2024/0041

88 Intake Lane, Pogmoor, Barnsley, S75 2HY

Two and a half storey side extension, loft conversion with flat roof box dormer extension on rear roof plane and new roof lights to front, single storey and one a half storey front extensions and conversion of 3 out of 4 bays of existing detached garage into a linked annex. (Resubmission) (Different proposal compared with application 2023/0214).

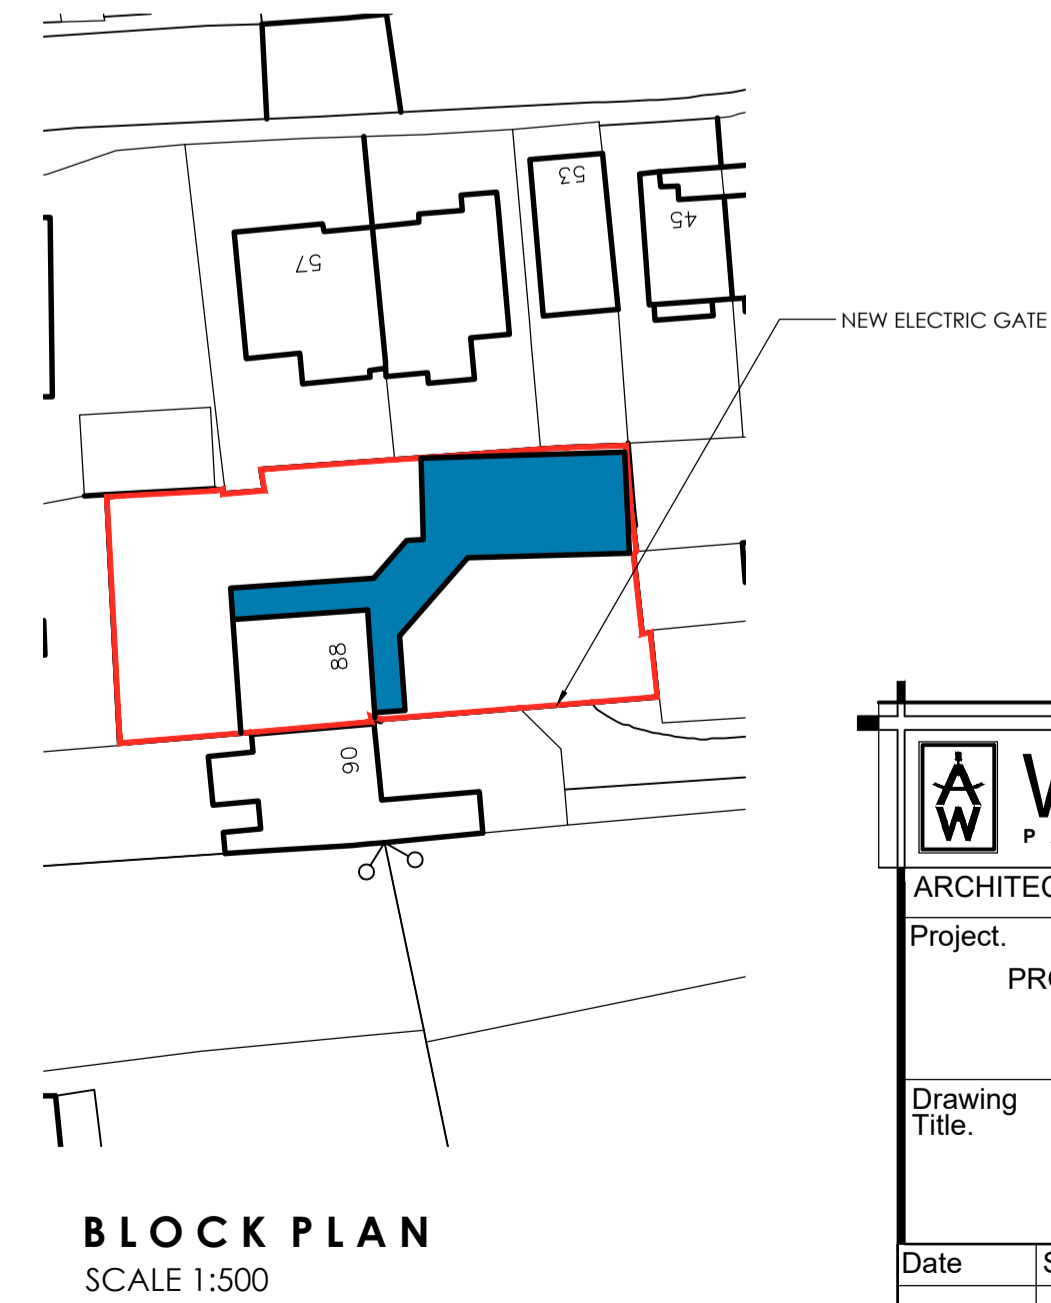
The main issue(s) in relation the proposed scheme (under consideration) lies with the fact that the proposed link would likely appear unnecessarily prominent and dominant, especially as the proposal would involve the relocation of the front door from the principal elevation of the main dwelling and the adoption of different external materials (slate cladding) that could bestow further emphasis on the proposed link. Moreover, the scale of the proposed link is considered to be excessive. The depth of the link (approximately 3.2 metres internally) is almost as large as the width of the largest ground floor rooms to the main dwelling (approximately 4.2 metres), and the width of the link, approximately 6.8 metres (measured at its longest point) would also be almost as wide as the entire internal width of the main dwelling (approximately 8.6 metres) as approved under planning application 2023/0214). The proposed link would therefore be tantamount to a large front extension. As such, the proposed link is not considered to be a modest nor sympathetic addition and could significantly alter and detract from the character and significance of the original dwelling and the approved scheme by significantly altering the principal elevation of the dwelling and in turn offering greater significance to the proposed link and approved annex, contrary to the House Extensions and Other Domestic Alterations SPD.

Whilst there is no general objection the principle of a link, it is considered that such development should not significantly alter or detract from the character of the original dwelling, should appear subservient to the main dwelling and approved annex, and should act as a modest walkable connection or corridor between the two spaces rather than providing any substantive additional

useable floorspace. As such, amendments were suggested. A revised scheme was received on 11th April 2024 that seemingly addressed the concerns raised. However, it was stated that the revised scheme appeared contrived and would create a narrow tunnel between the dwelling and garage conversion and was not a type of design that the applicant wished to pursue. The applicant therefore chose to proceed with the initial proposal of a larger link.
